**From:** Euan Clark - Folkes Architects <[REDACTED]>  
**Sent:** 11 November 2019 13:21  
**To:** Anita Gardner <Anita.Gardner@arun.gov.uk>  
**Subject:** RE: EP/109/19/PL - Variation of condition 2 - Amended Plans reducing footprint and massing

“Variation of a condition following grant of planning permission EP/121/17/PL relating to condition no.2 - plans – amended and relocated footprint & amended massing”.

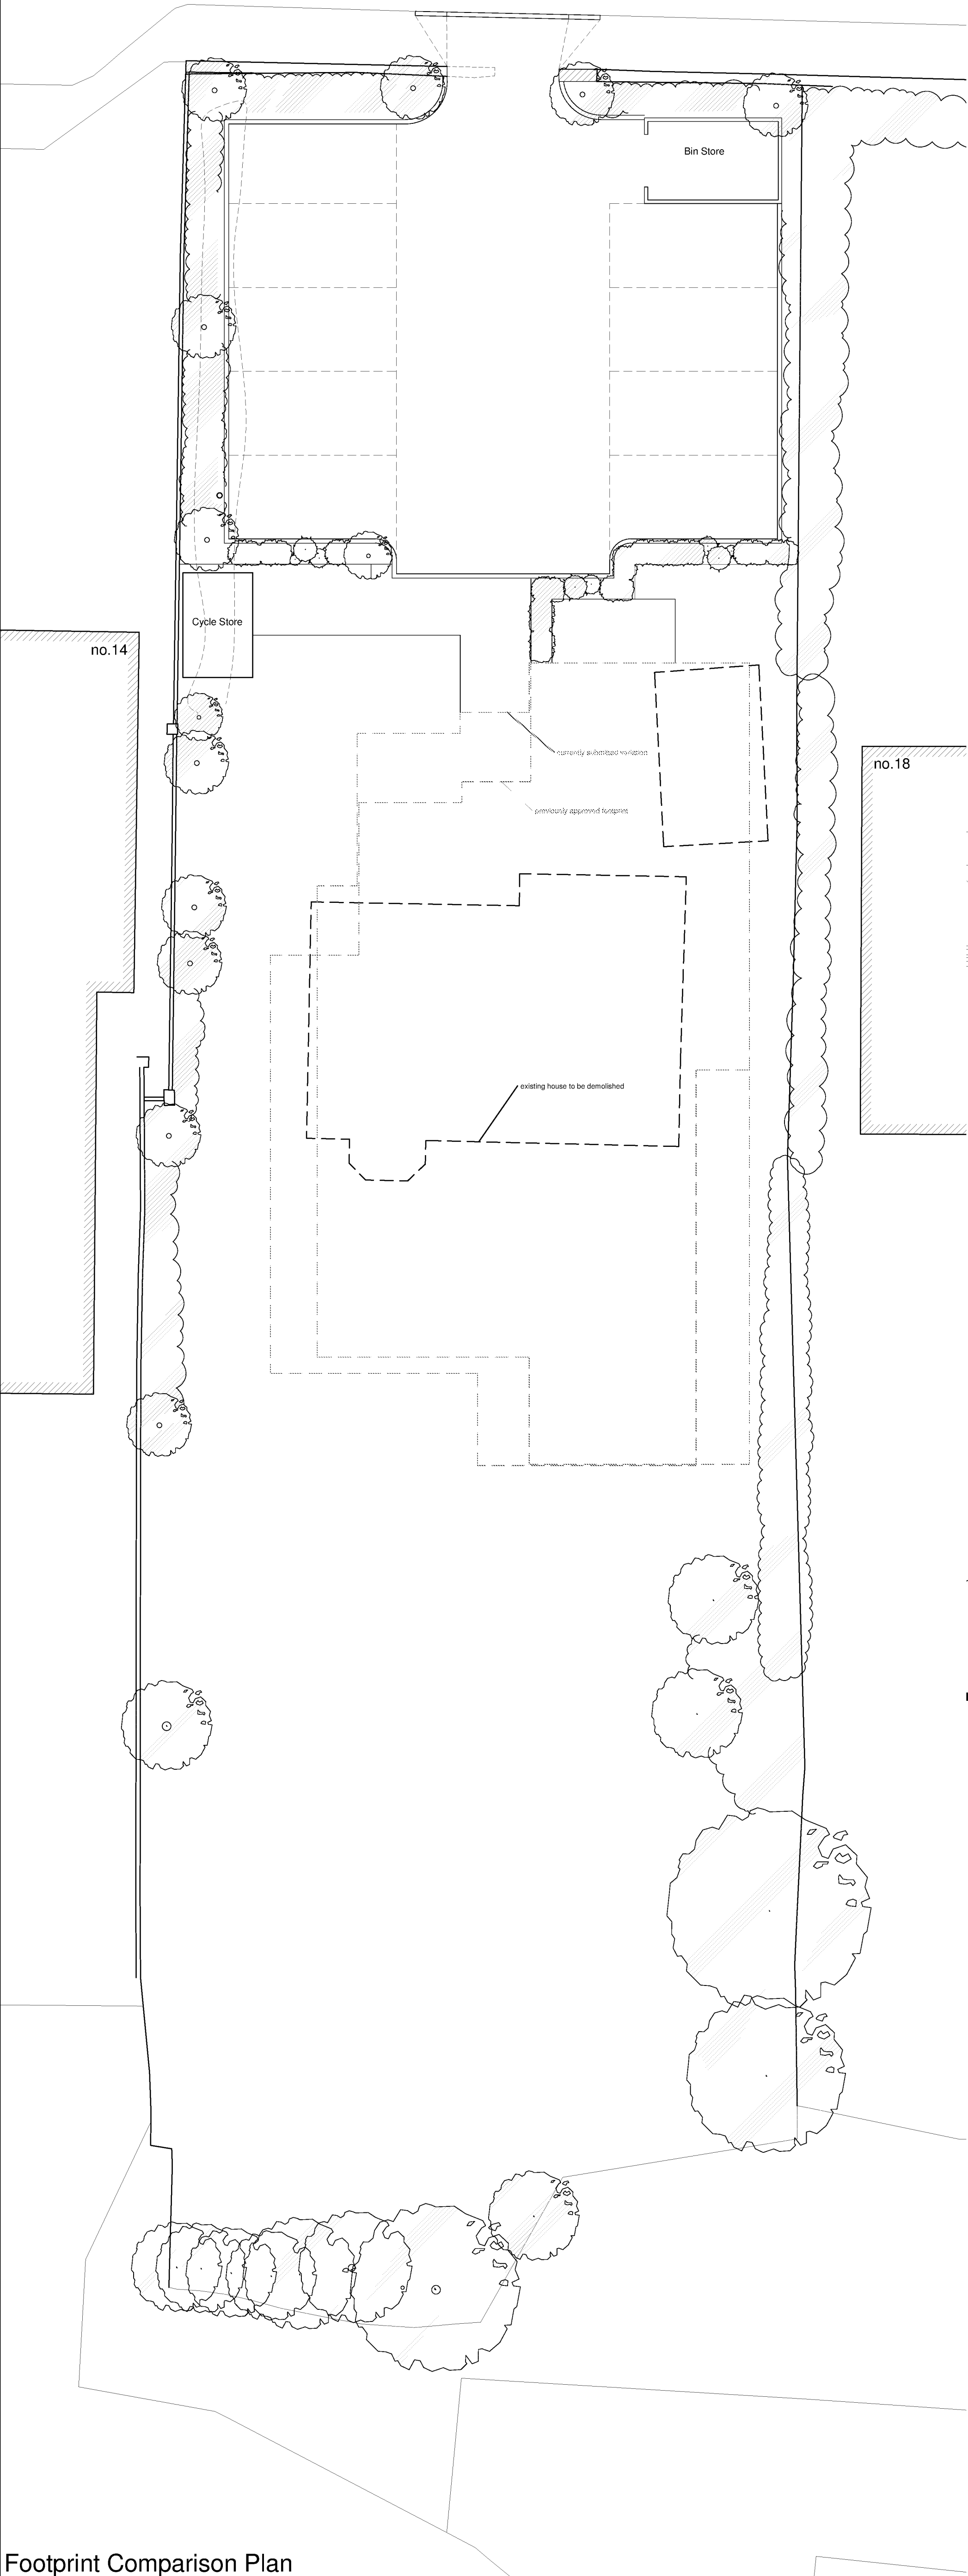
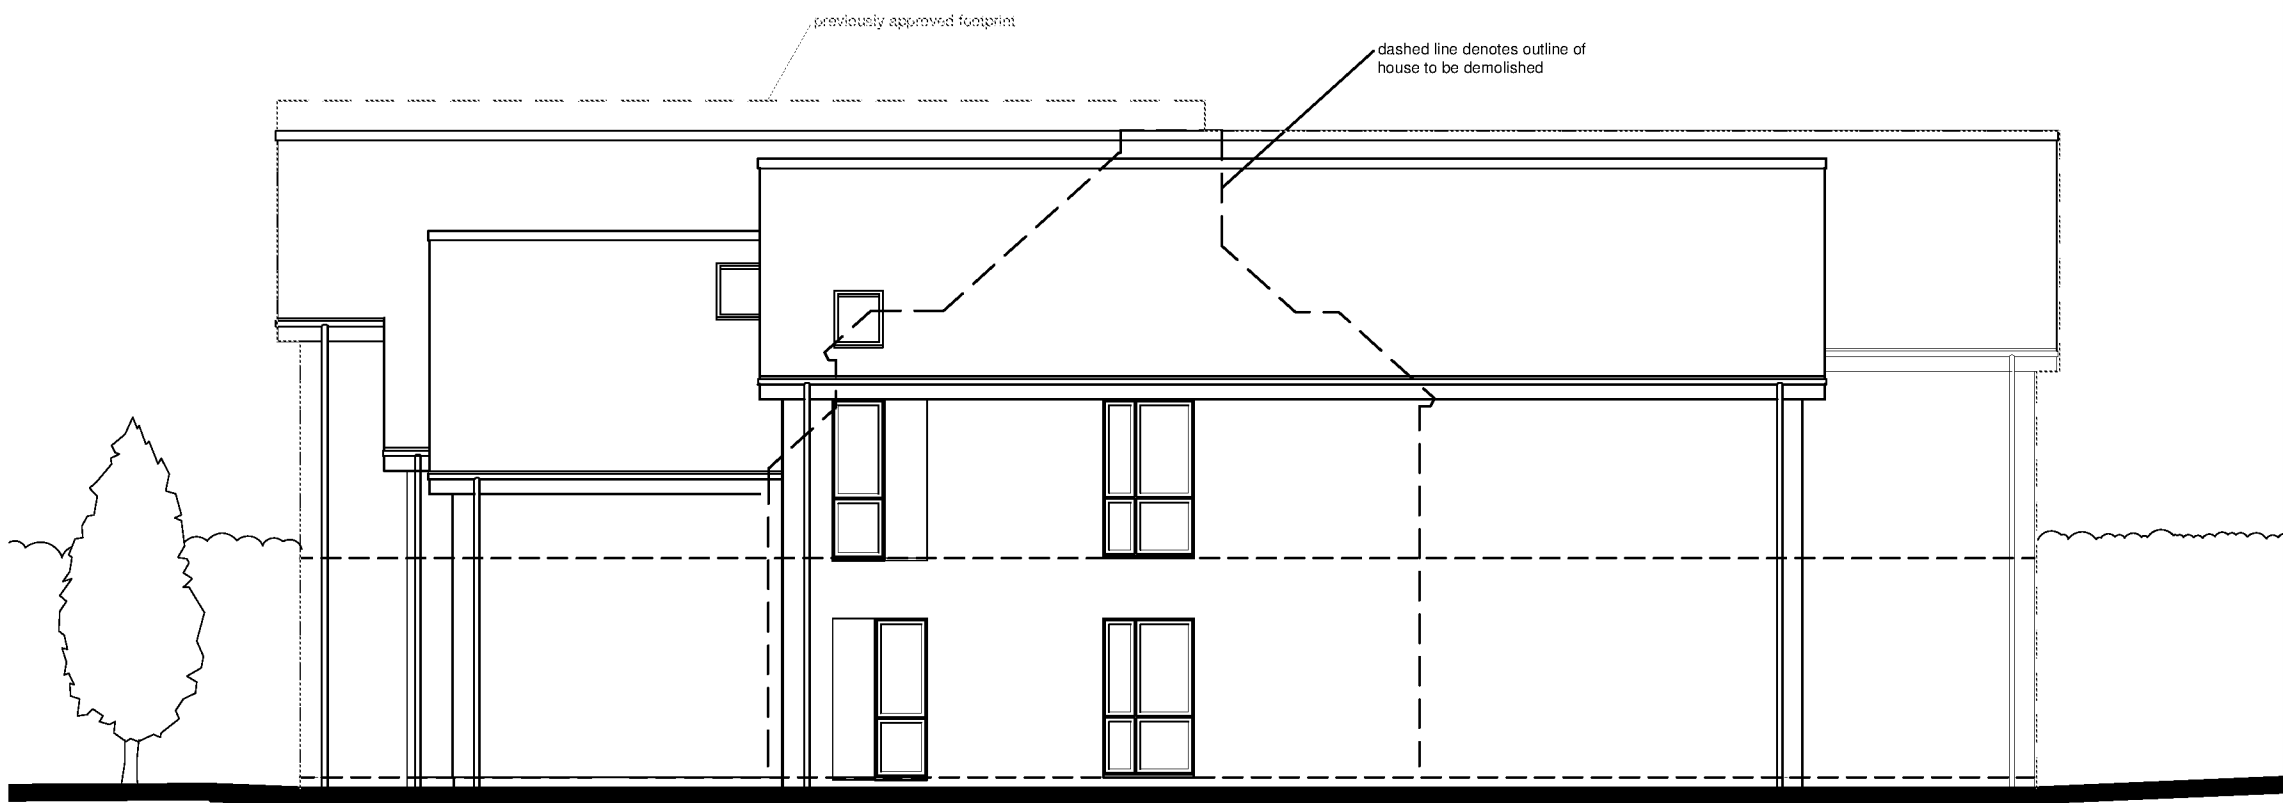
Thank you for the comparative plan. It illustrates that the massing is not reduced on the site boundary with no 18 and I think it is questionable that the footprint is reduced. The footprint appears to be amended, but not necessarily reduced and any reduction is not readily apparent and looks to be minimal. It would be helpful to know how much the area of the footprint has changed when measured in m2.

I am concerned that the description which was taken from the application form is misleading and may well have been taken at face value by adjoining residents (particularly no 18) who will have assumed that the impact on their property from the description given has been improved, when it is not the case.

Having reviewed the comparison drawing the revised scheme is 7m2 larger than the original scheme, but as you say, the volume has decreased.
